Re: Planning Application 18/0984

Address: Deli Solutions Ltd Lincoln Way Clitheroe BB7 1QD

Description: Proposed additional car parking for Deli Solutions and Farmhouse
Fare along Lincoln Way Clitheroe

Drawing Title
Proposed Site Plan
Deli Solutions (1:200 Scale)

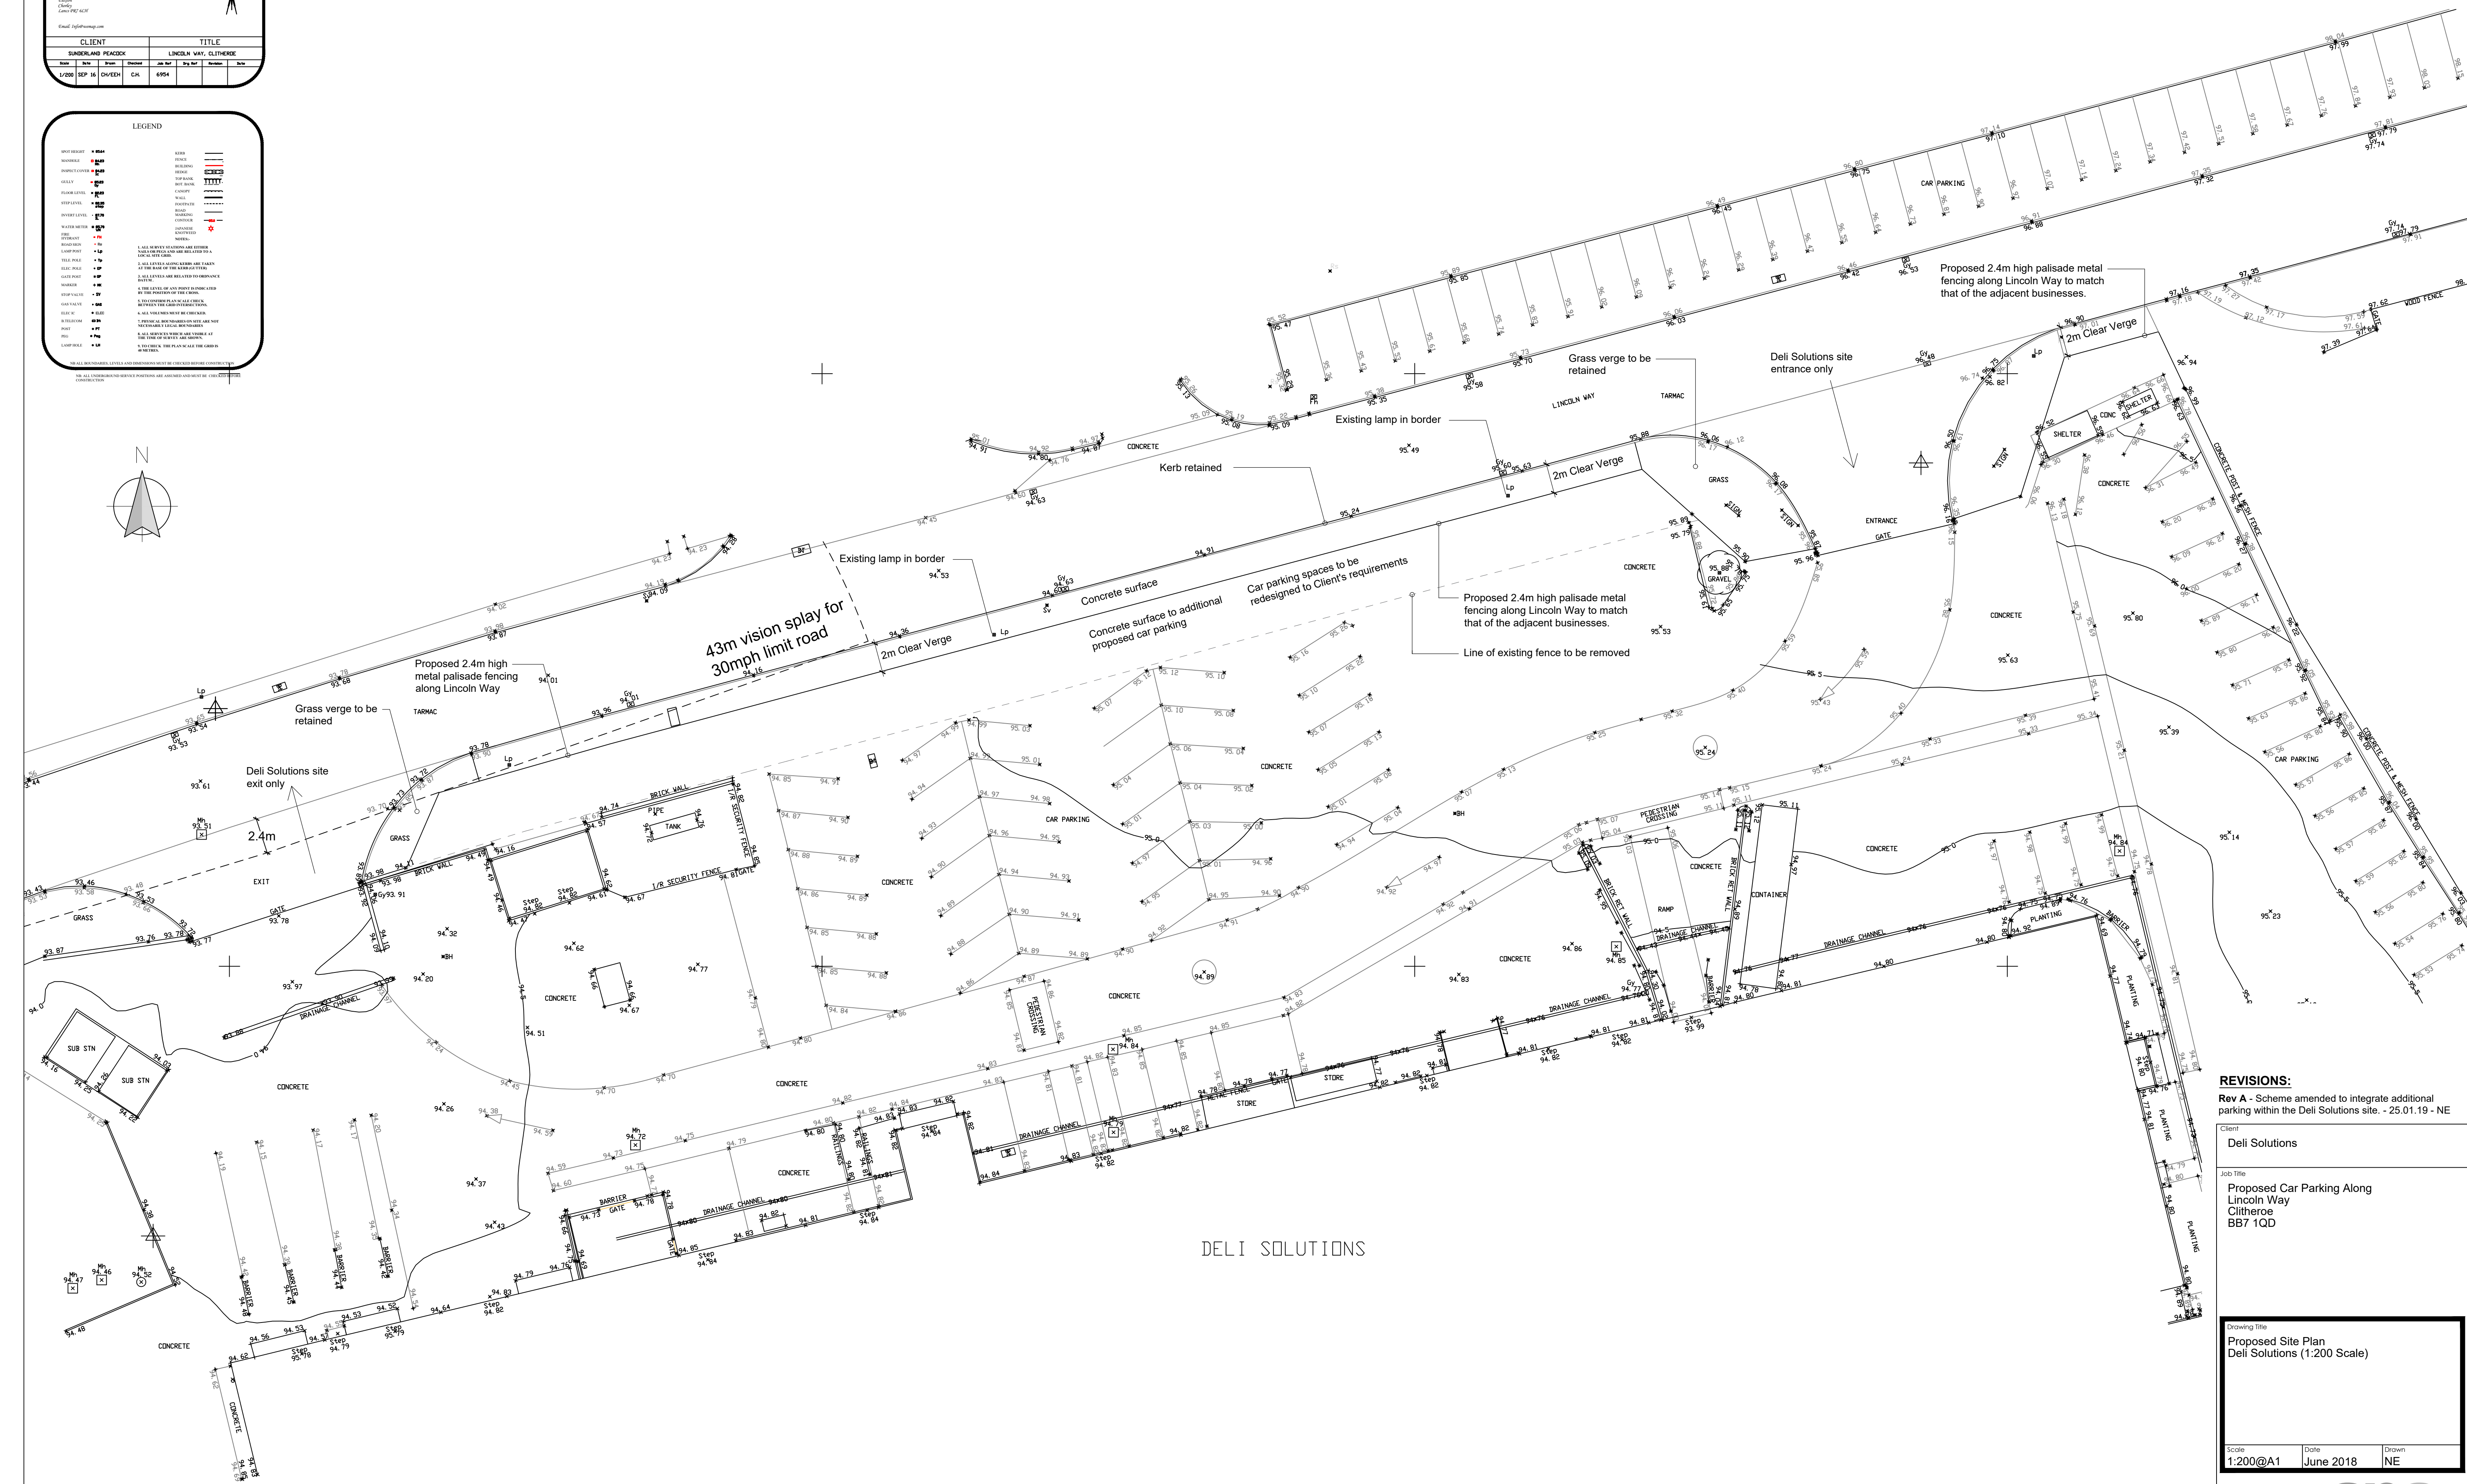
Part of the area covered by the works will upon completion form part of the adopted highway and will need to be constructed to adoptable standards, under a Section 278 agreement of the 1980 Highways Act. The works will also require some thought to be given to the drainage of the car parking area.

It is recommended that parking areas are lined and numbered in accordance with the plan provide with the application, and that there should be some signage to indicate that they are private parking spaces.
